Towner/Stapleton

Summary of Comments on TIS County Comments 10-15-18 w LSC Responses.pdf

PAINT BRUSH HILLS FILING 13E
CONSTRUCTION PLANS
STREET IMPROVEMENT PLANS
KEATING DRIVE

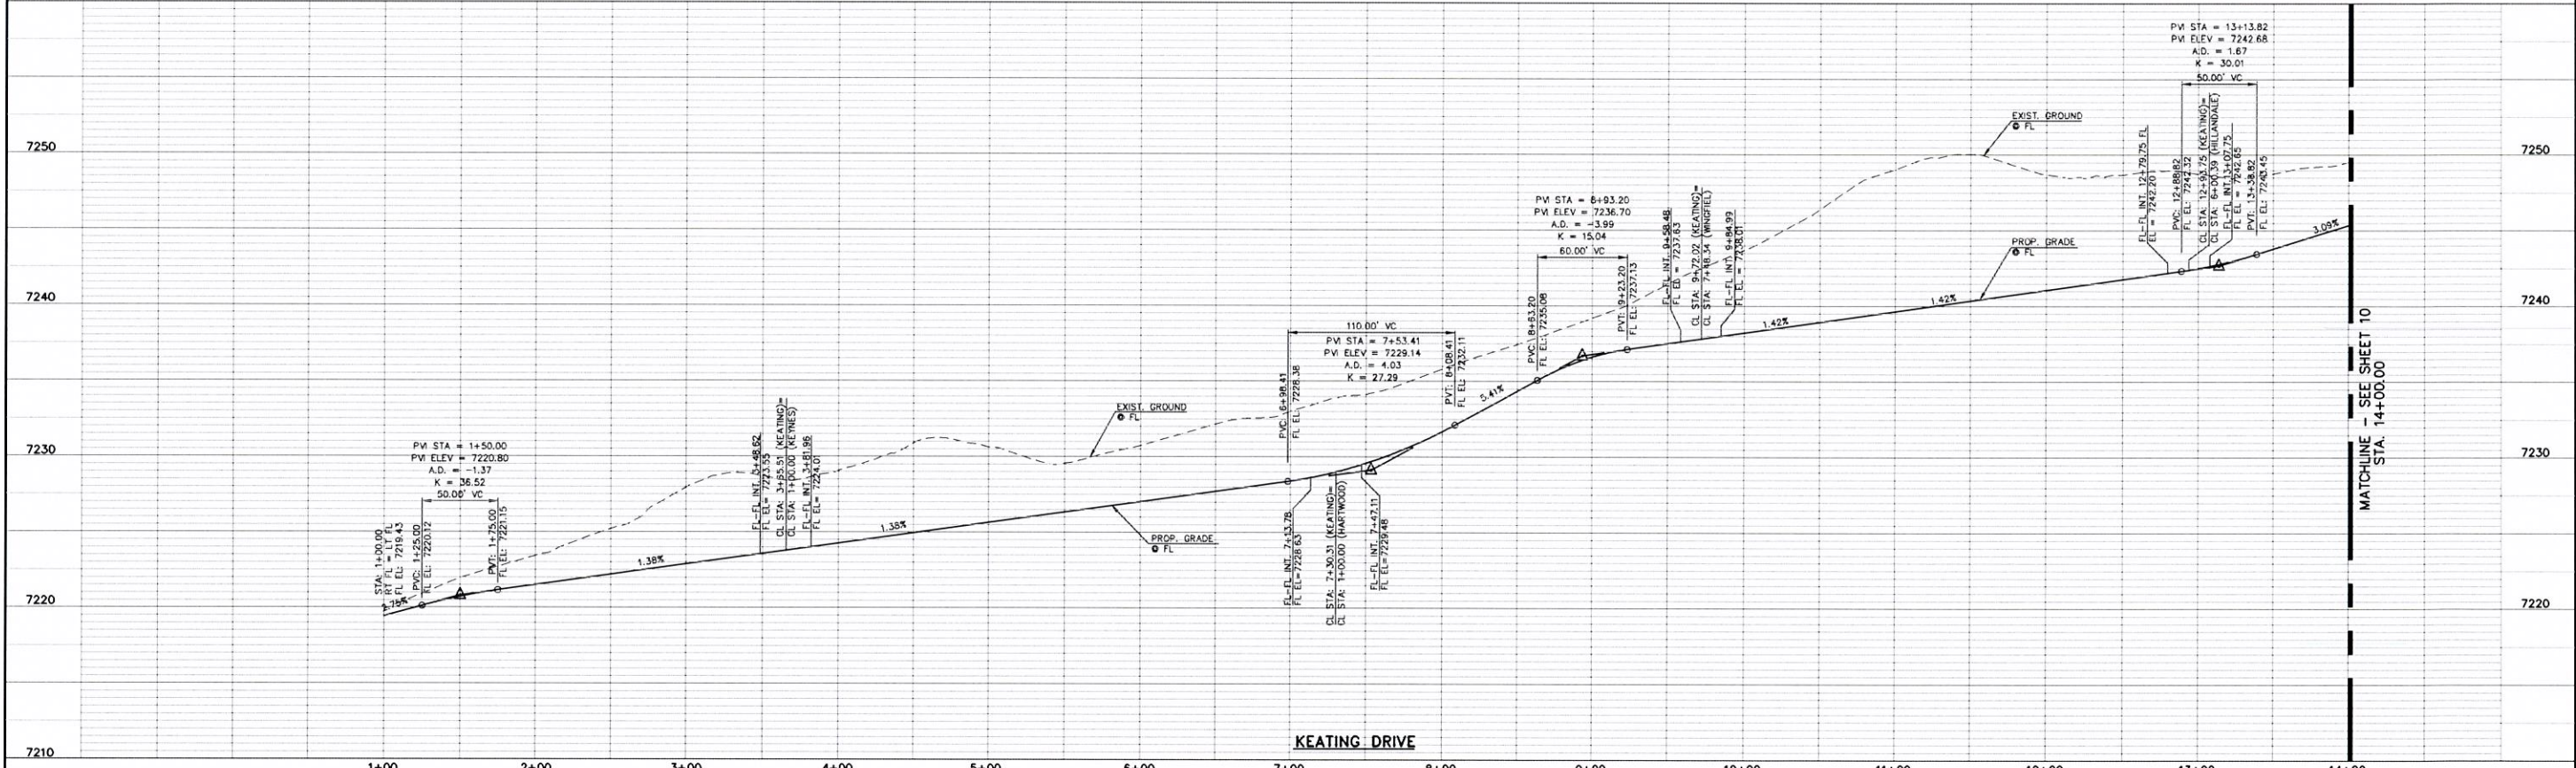
There seems to be a disconnect with the construction drawings. The construction drawings and plat identifies Keating Drive and Asbee as a Residential Collector.

LSC Response (10-22-18): It is our understanding that the construction drawings and the plat have been updated. We have added clarification regarding the existing streets with 60-foot ROW in the updated report. Devoncove Drive should also be a Local street based on buildout of Filings 13E and 14.
